Our ref: HA/2020/122604/03-L01
Your ref: LU/247/20/PL
Date: 24 November 2020

FRA SUBMITTED - PARTIAL DEMOLITION OF EXISTING BUILDING, RETENTION OF BOUNDARY WALL & STREET FACADE, PARTIAL DEMOLITION OF BOUNDARY WALL TO INCORPORATE NEW PEDESTRIAN GATEWAY & GATE, ERECTION OF 6 NO. FLATS IN 2 BLOCKS CONNECTED BY SHARED STAIR & LIFT CORE, ON SITE PARKING YARD FOR 8 NO. CARS & 8 NO. CYCLES & SPACE FOR COMMUNAL REFUSE & RECYCLING BINS. THIS APPLICATION AFFECTS THE CHARACTER & APPEARANCE OF THE LITTLEHAMPTON RIVER ROAD CONSERVATION AREA & IS IN CIL ZONE 4 AND IS CIL LIABLE

57 RIVER ROAD LITTLEHAMPTON BN17 5DD

TITLE: PROPOSED SECTION B

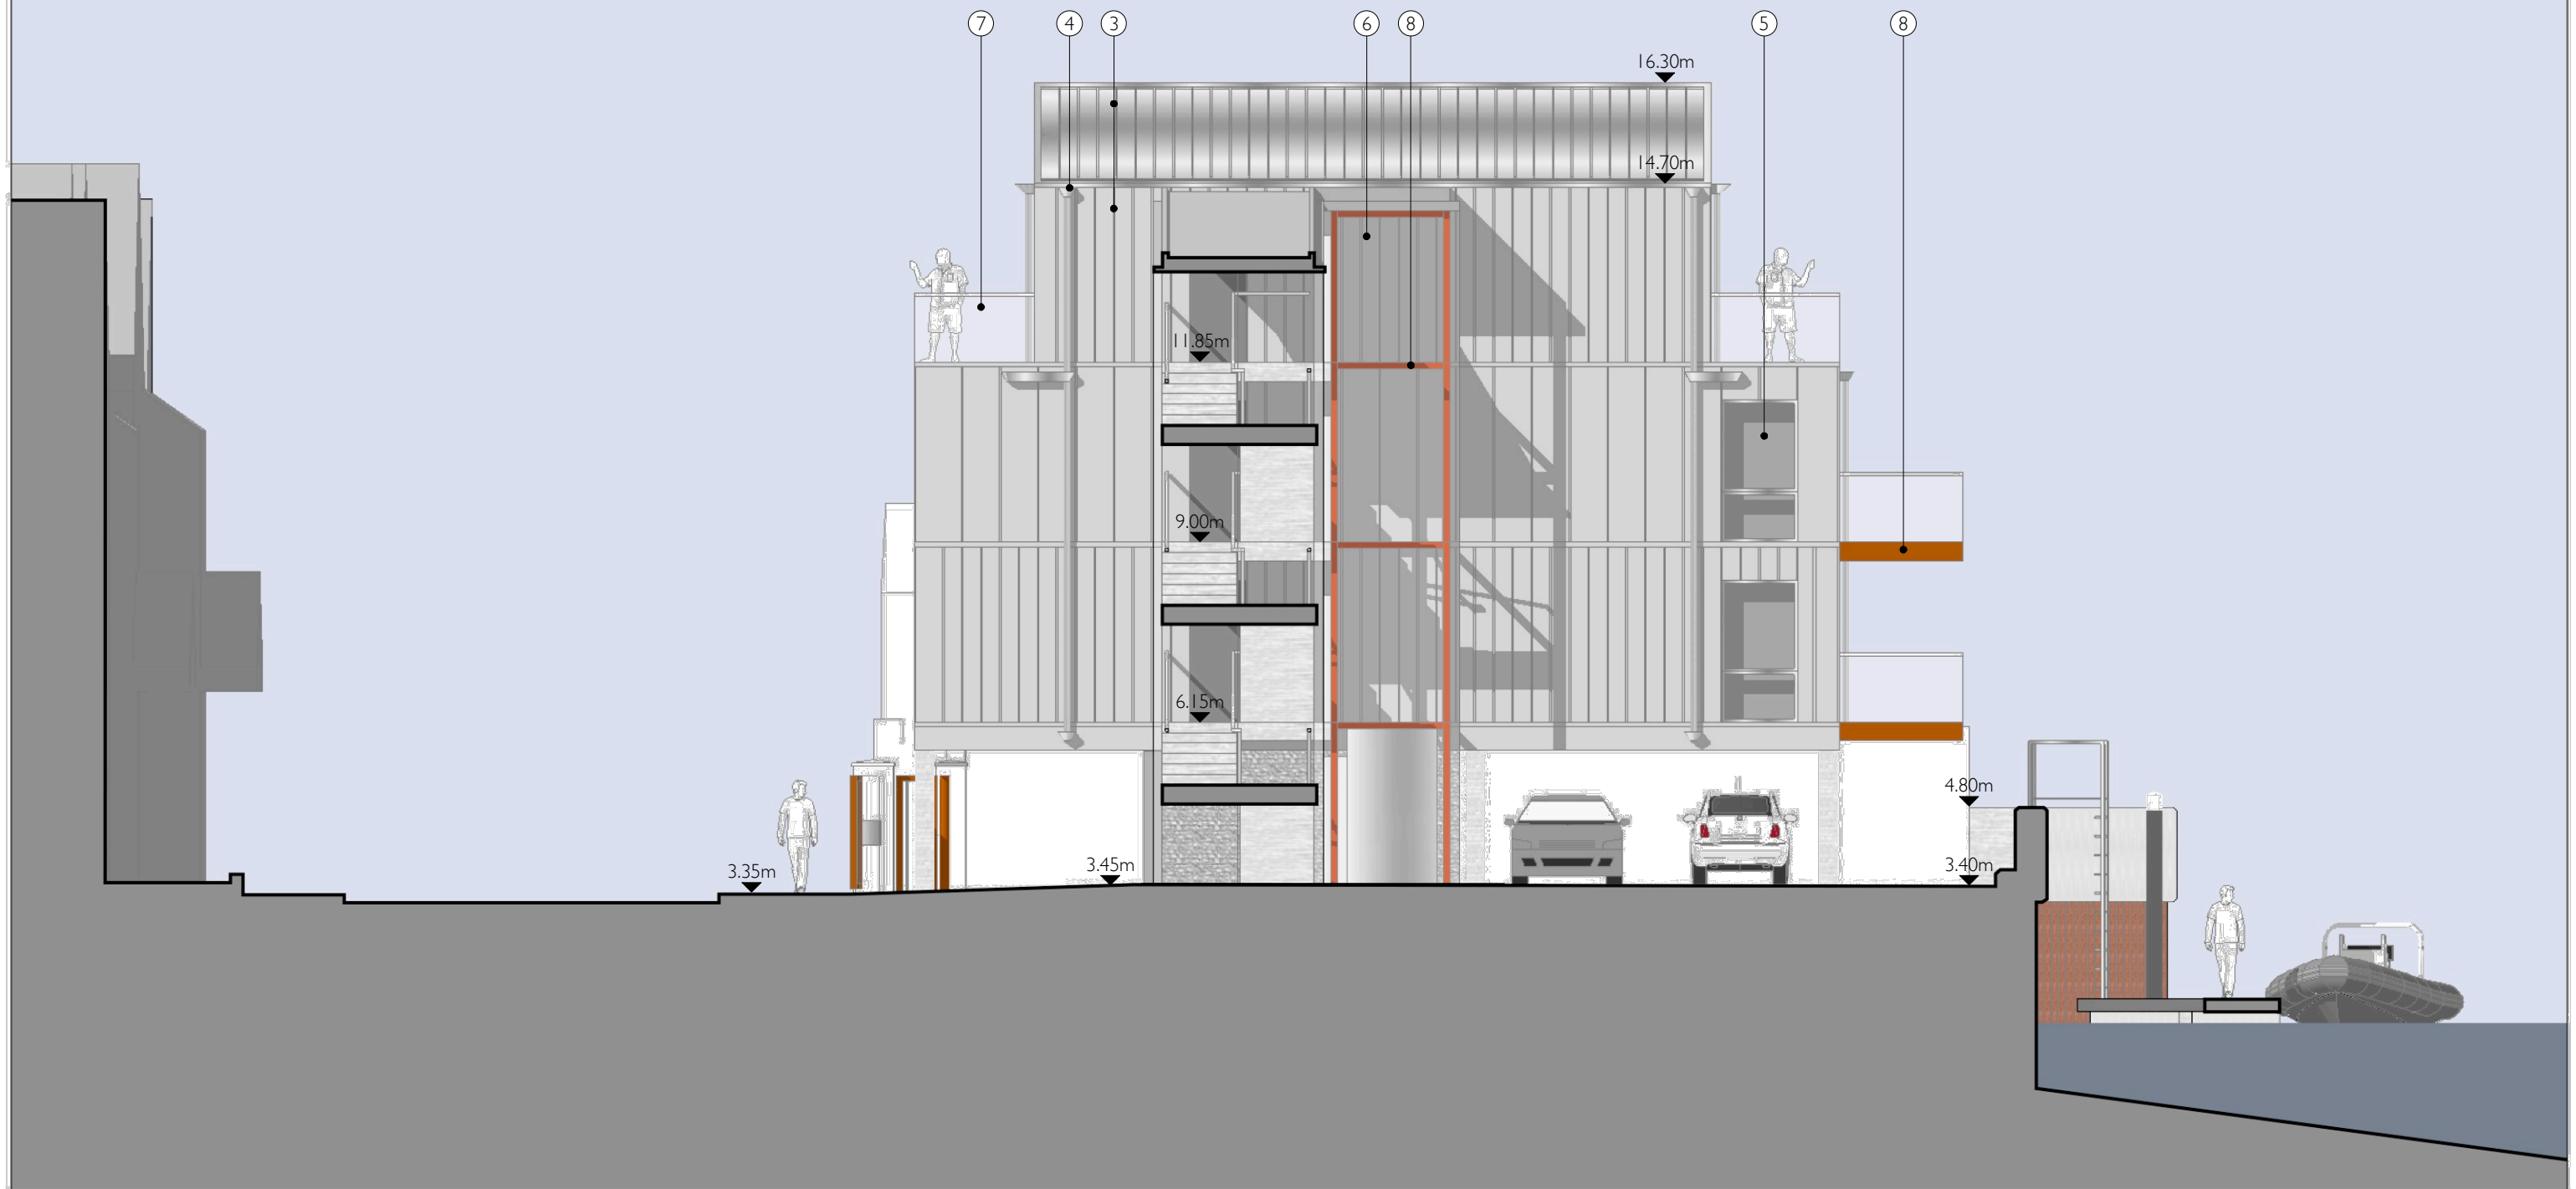
- **The Ground Floor Finished Floor level of the development must be set no lower than 5.17mAOD**

Providing all the finished floor levels are set no lower than 5.17mAOD, the development is likely to remain free of inundation over its lifetime. Safe refuge is available within the building. The LPA should be satisfied that the building can remain structurally sound given the potential flood depths (1.47m) possible at the site.
